Application for a Non-Material Amendment Following a Grant of Planning Permission

Slight adjustment to the side windows of plot 1 & 3
Slight widening of the front window of plots 1 & 3
Slight changes to the internal layouts on both plots

DRAWING No. :
 ~ FER-2206 - P1_3.01 ~

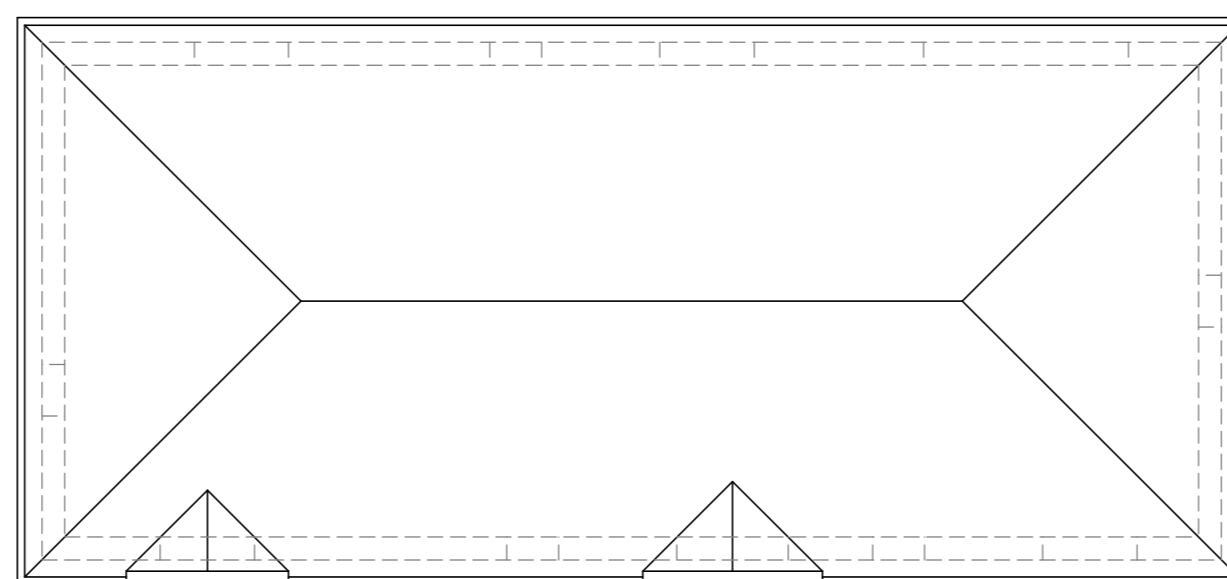
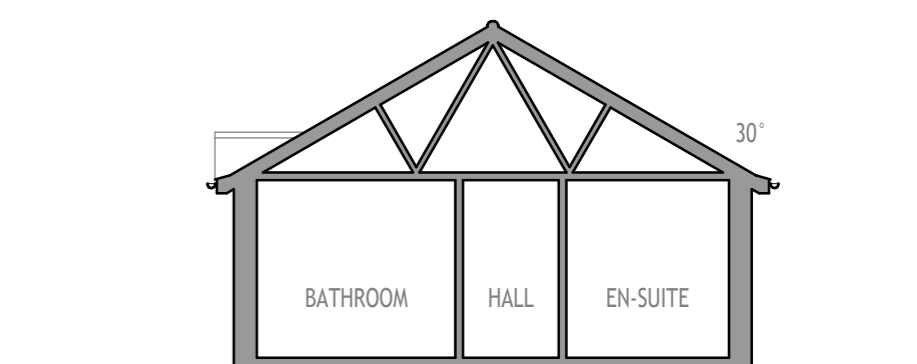
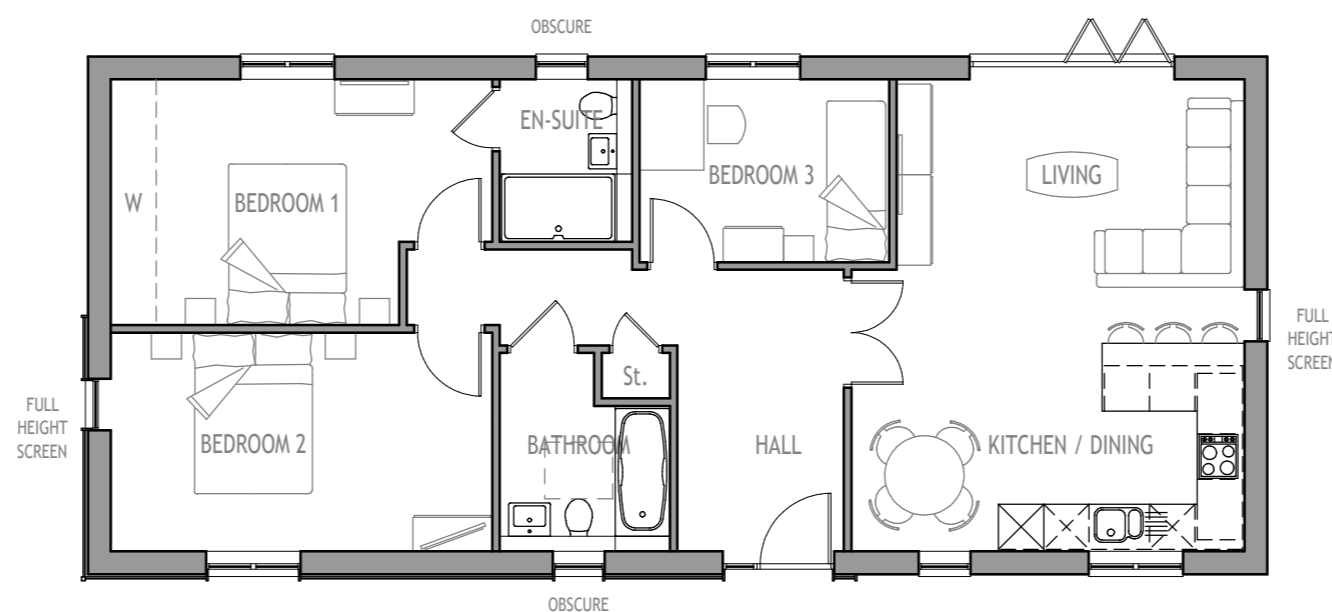
To improve the internal layouts of both plots and to make the necessary adjustments to the windows accordingly.
